From: Contact Centre (CRM) <contact@ribblevalley.gov.uk>
Sent: 16 September 2026 14:22
To: Planning
Subject: Planning Application Comments - 3/2026/0635 FS-Case-874453350

Planning Application Reference No.: 3/2026/0635

Address of Development: Land east of Clitheroe Road Whalley.

I write to object to planning application 3/2026/0635 for the proposed development of 39 dwellings on land east of Clitheroe Road, Whalley.

Figure 3.2 : Proposed Site Access Arrangement

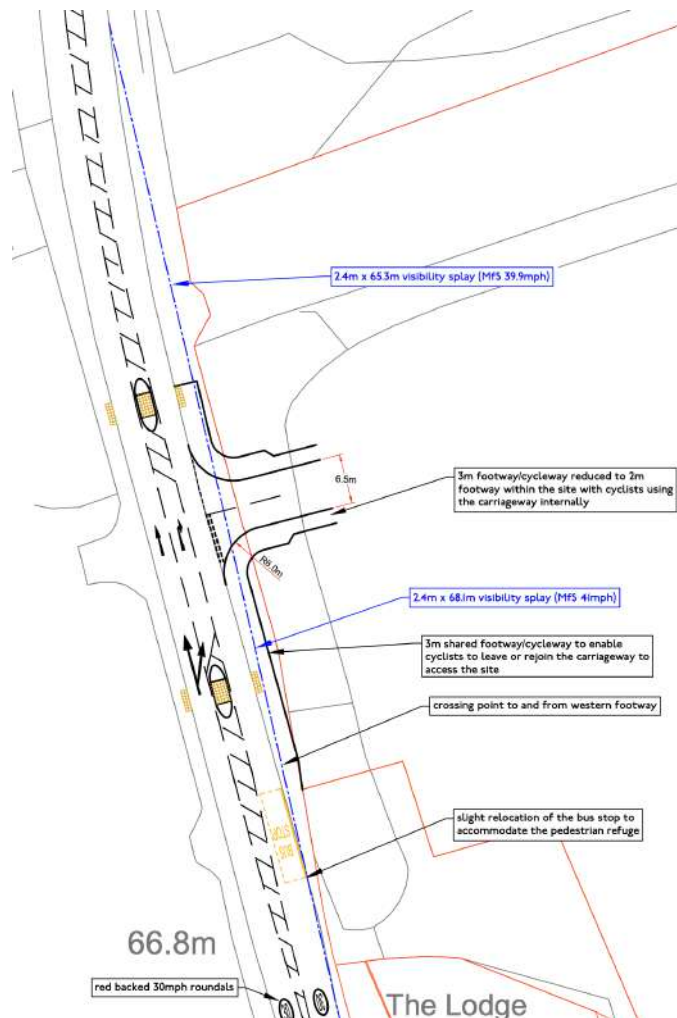
Residents walking towards Whalley would therefore need to cross 40mph (of which cars travel much faster) Clitheroe Road to join the existing pedestrian route into the village.

The development therefore proposes new crossing/refuge provision, traffic calming, a proposed 30mph environment, a ghost right-turn lane and shared pedestrian/cycle provision around the access.

These measures demonstrate that the site's claimed accessibility is wholly dependent upon new major highway intervention rather than existing conditions. Interventions that I also do not see to be possible given the width of the road and positioning of the opposing neighbours driveway entrance. I consider this relevant to the S5 question of whether the site is physically well-related to Whalley.

My concern is would the proposed crossing, visibility and speed-management measures create a sufficiently safe and attractive pedestrian relationship with Whalley given the existing highway conditions and actual vehicle speeds.

Figure 3.3 : Proposed Clitheroe Road Traffic Calming Scheme

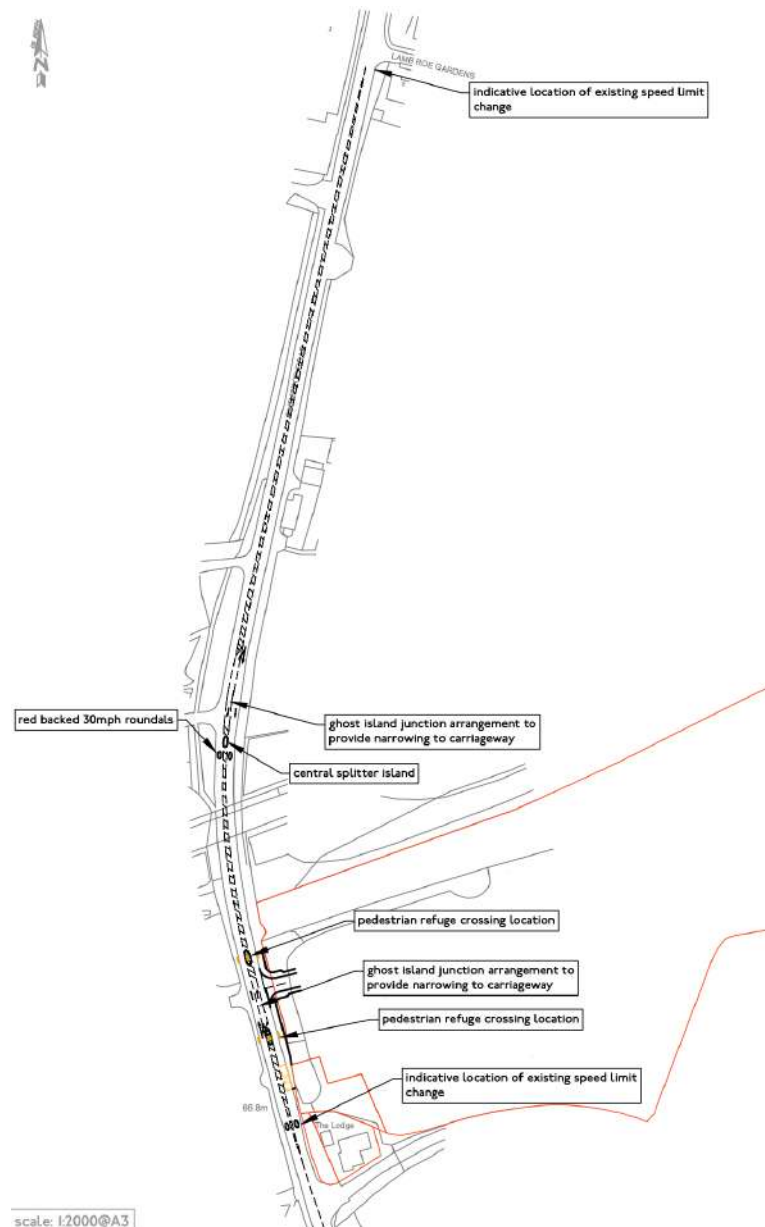
There would also be a change to the character of Clitheroe Road through the new estate junction, ghost right-turn lane, pedestrian crossing infrastructure, altered bus-stop arrangements and traffic-calming measures. These may be necessary to serve the development, but their cumulative urbanising effect is extremely relevant when considering the character of this approach to Whalley.

Figure 4.1 : Walking Catchment Area with Local Amenities

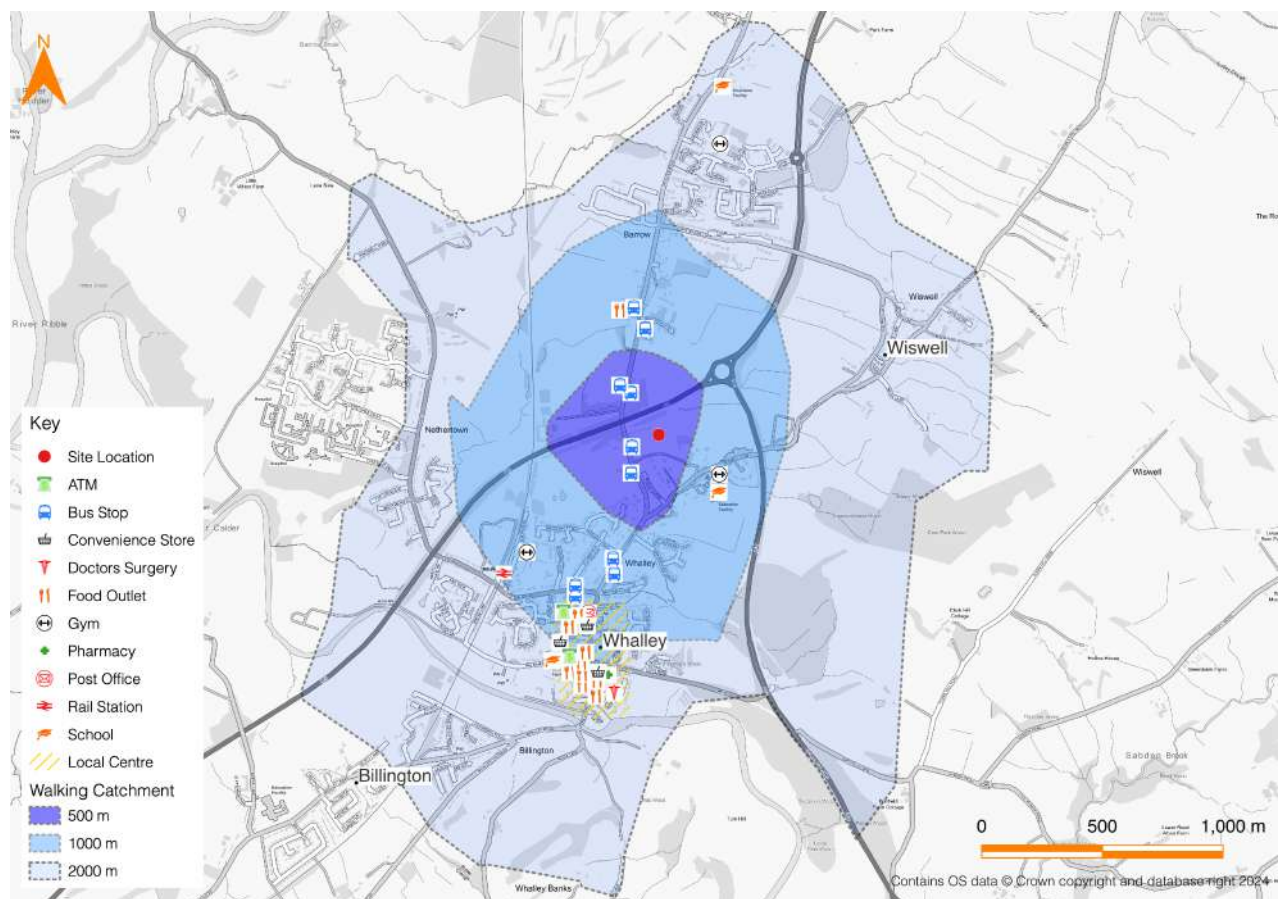
The Transport Statement gives walking times of approximately 11 minutes to Whalley centre and 14 minutes to the railway station. These figures should, in my view, be considered alongside the actual quality of the route, including the need to cross Clitheroe Road, the busy main through road to Clitheroe from Whalley and surrounding areas.
